Berry, Huff, McDonald, Milligan Inc.
Engineers, Surveyors

August 20, 2014

RE: Level I-Minor Residential Development Review Site Plan Revisions
218 Washington Avenue – Glenn Morse
Application #2014-01234

Drawing file: 4. Revised Plans / S2-1 Sections.pdf

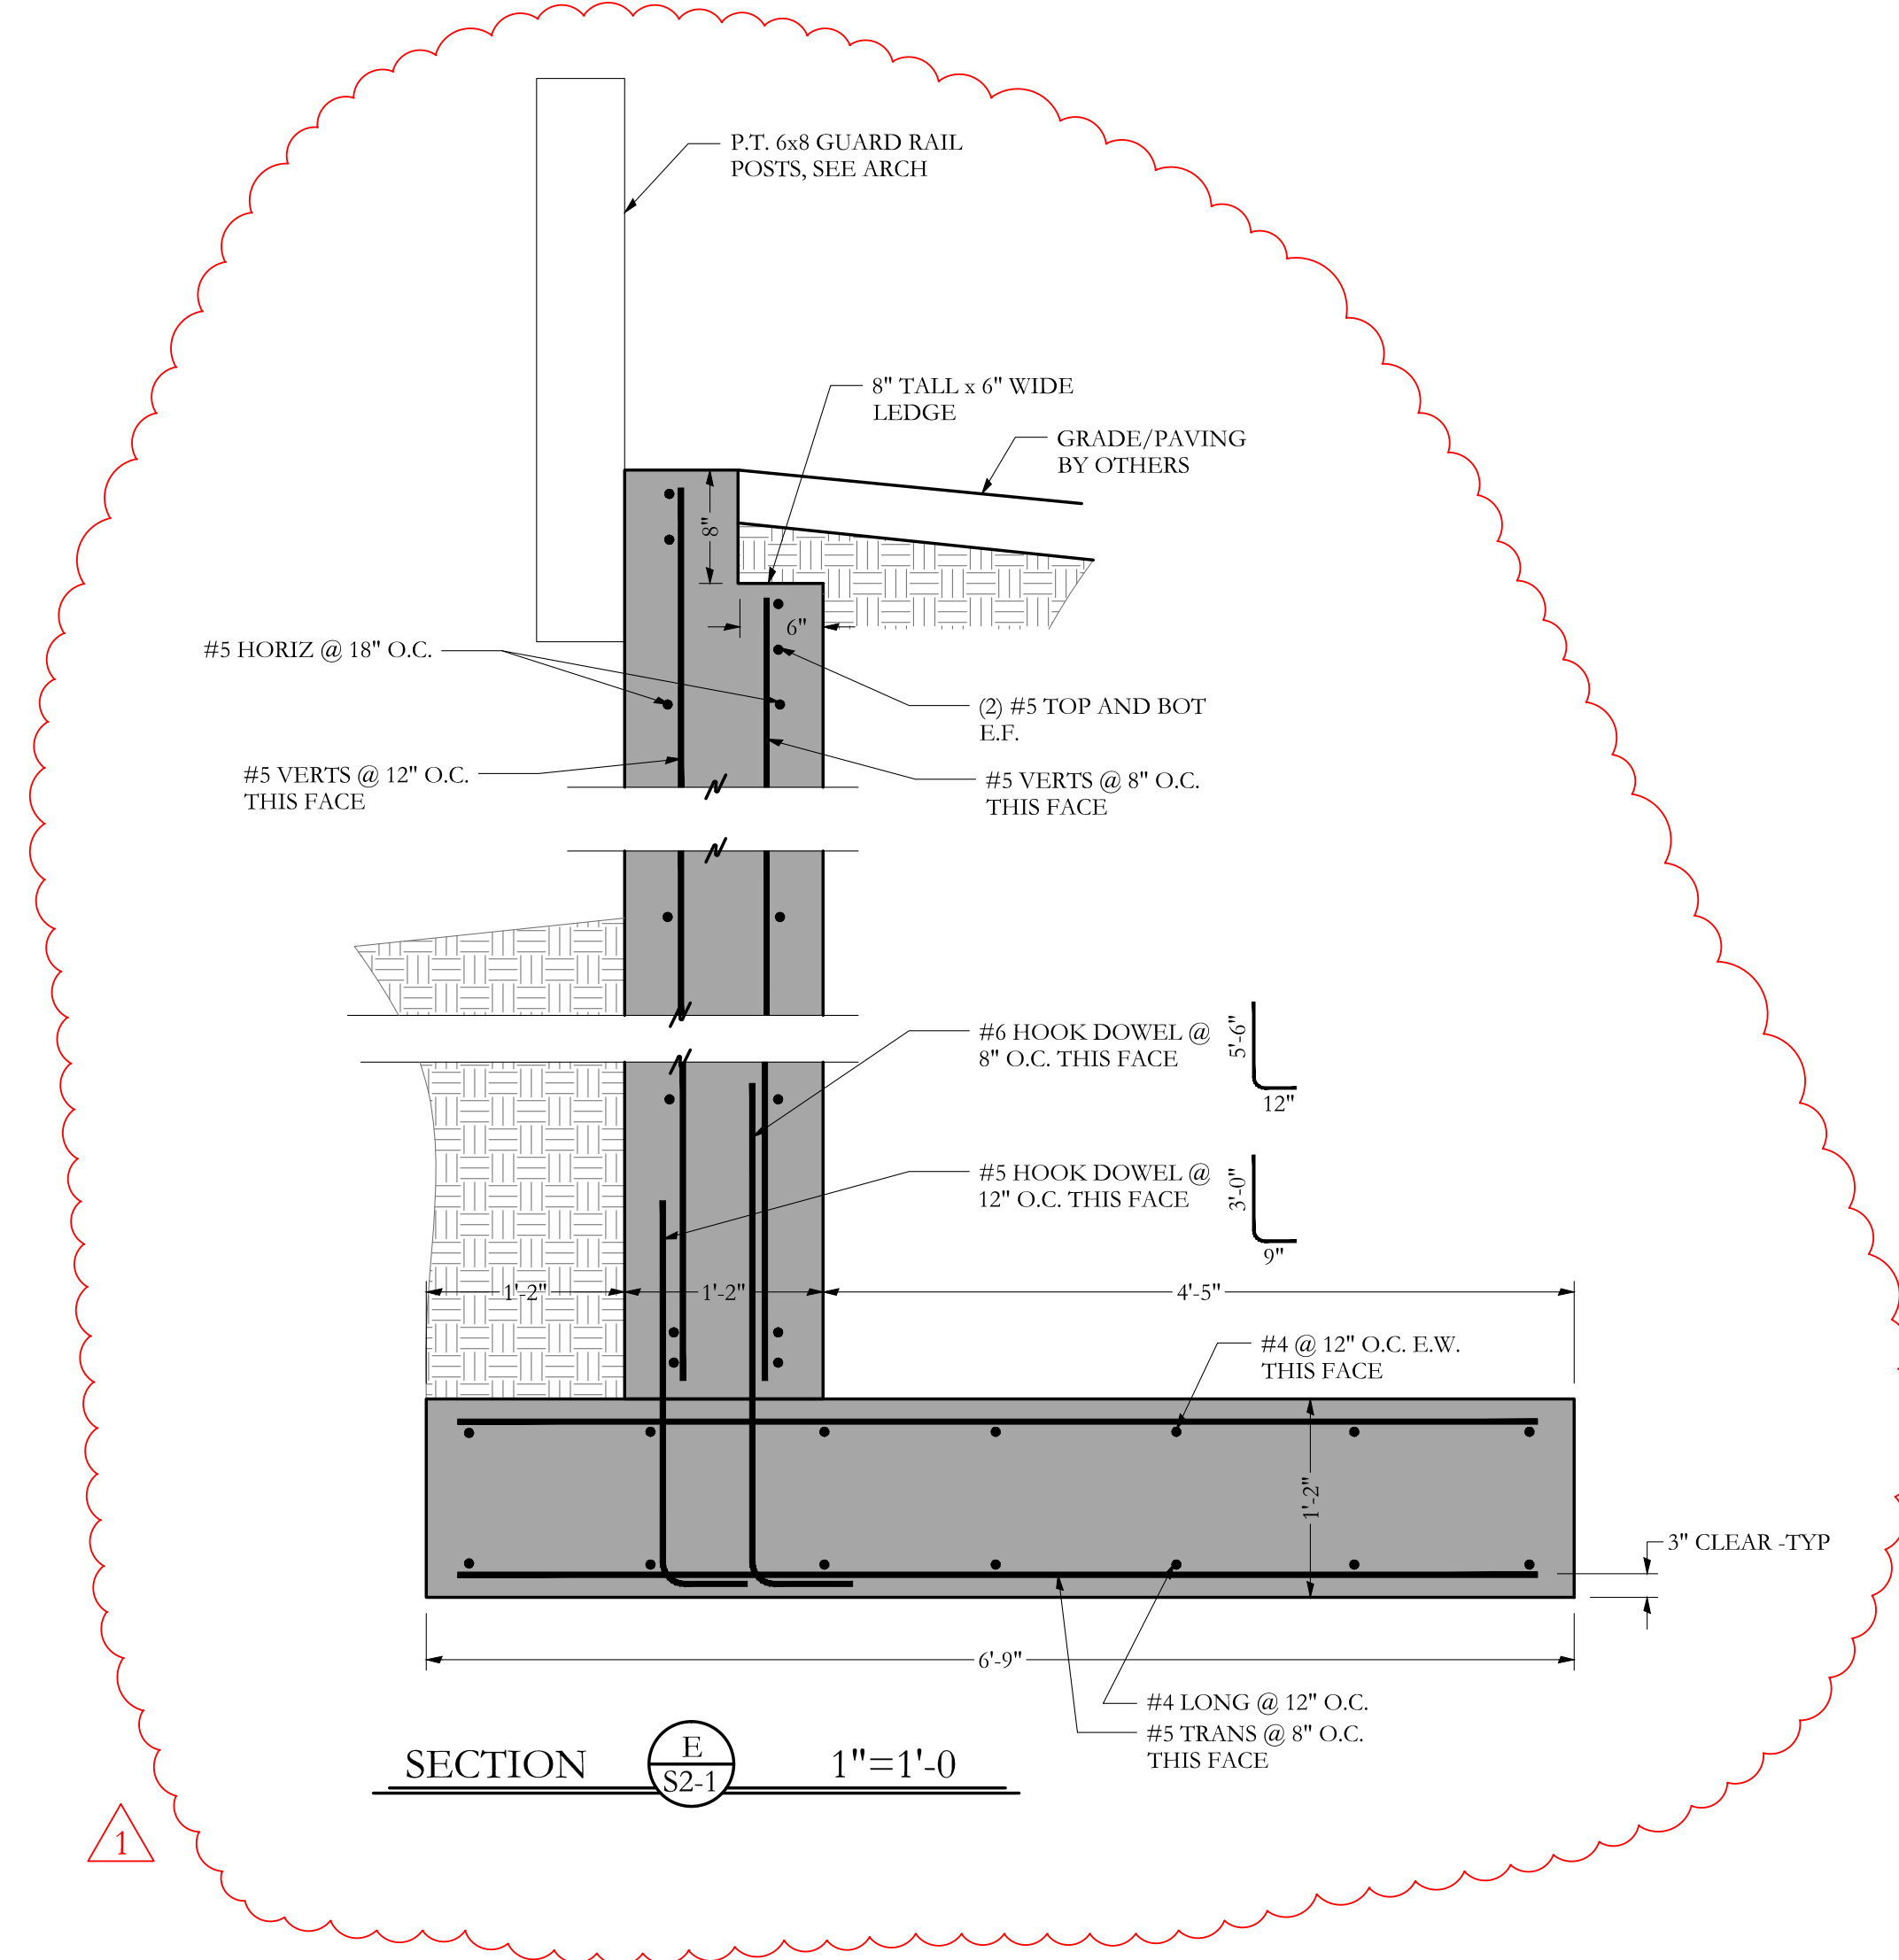
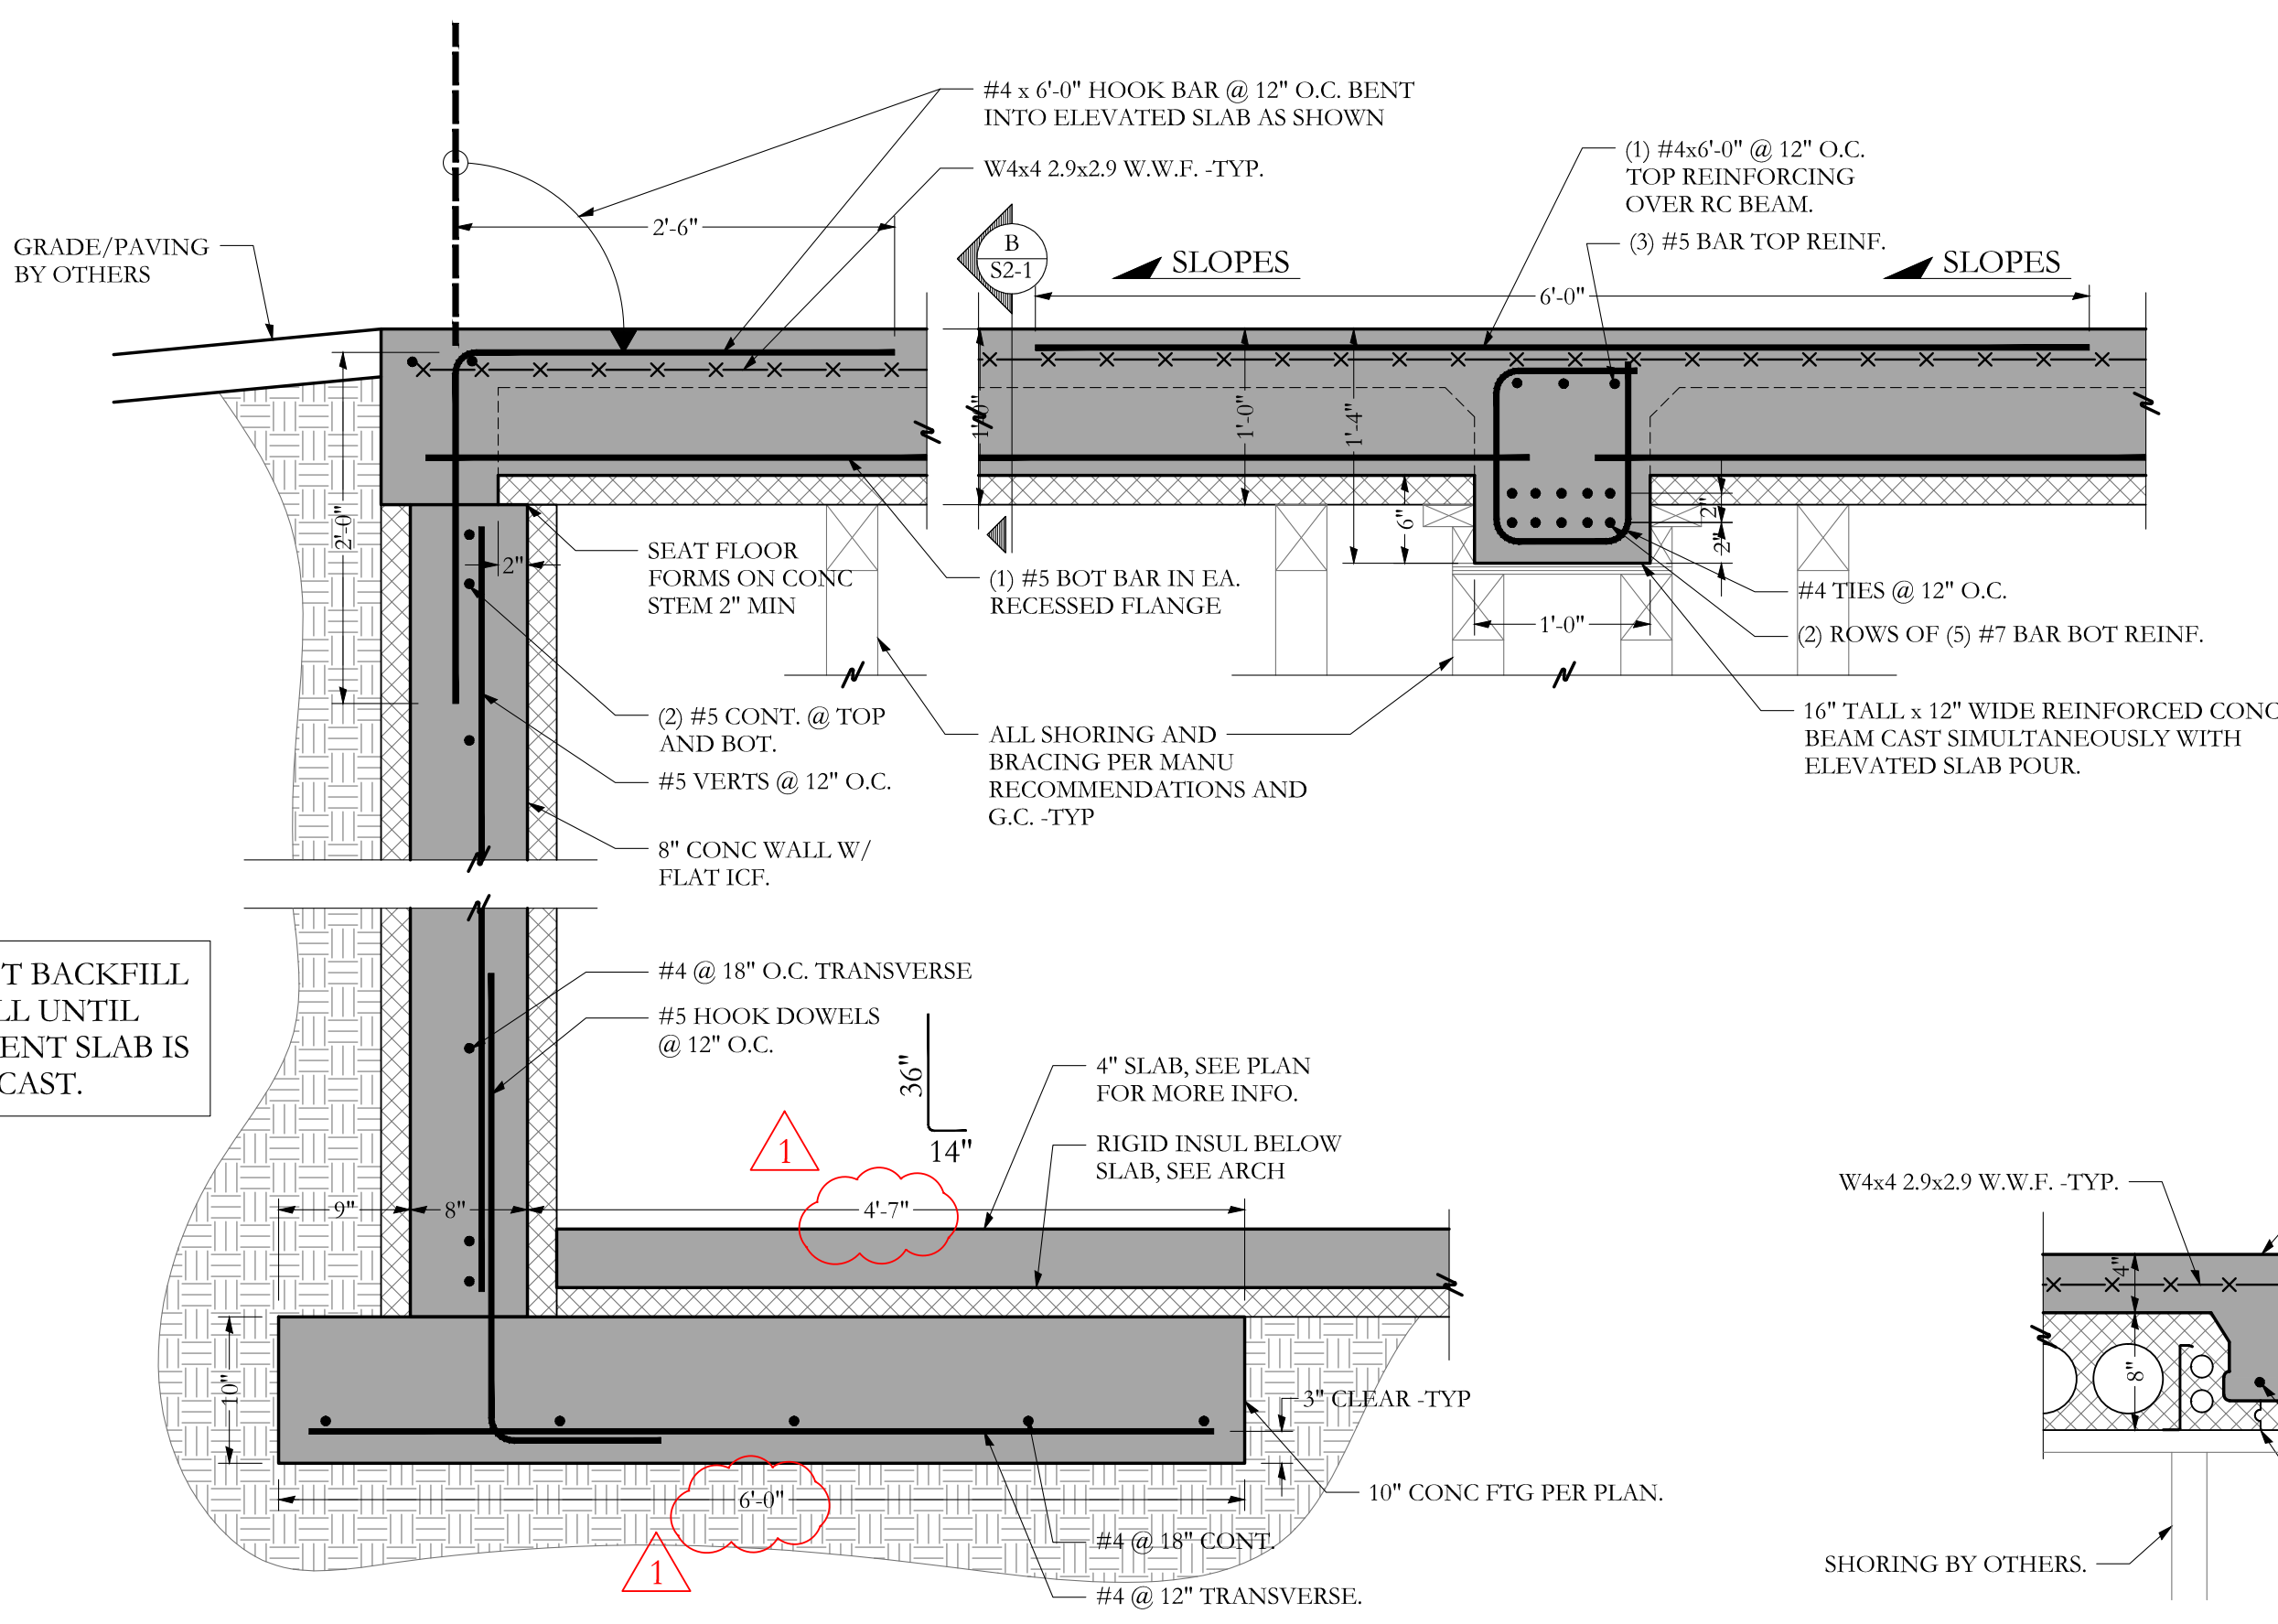
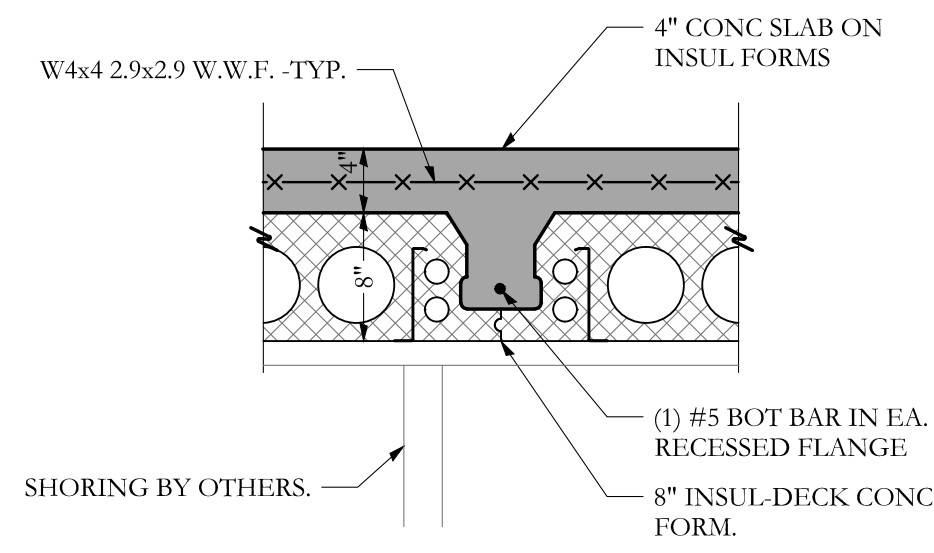
2. A grading and construction easement has been added to the abutting lot along with dimensional requirements for the City to review.
3. The retaining wall on the Northern side of the building is a proposed retaining wall. Please find attached the design by Structural Integrity Consulting Engineers Inc.
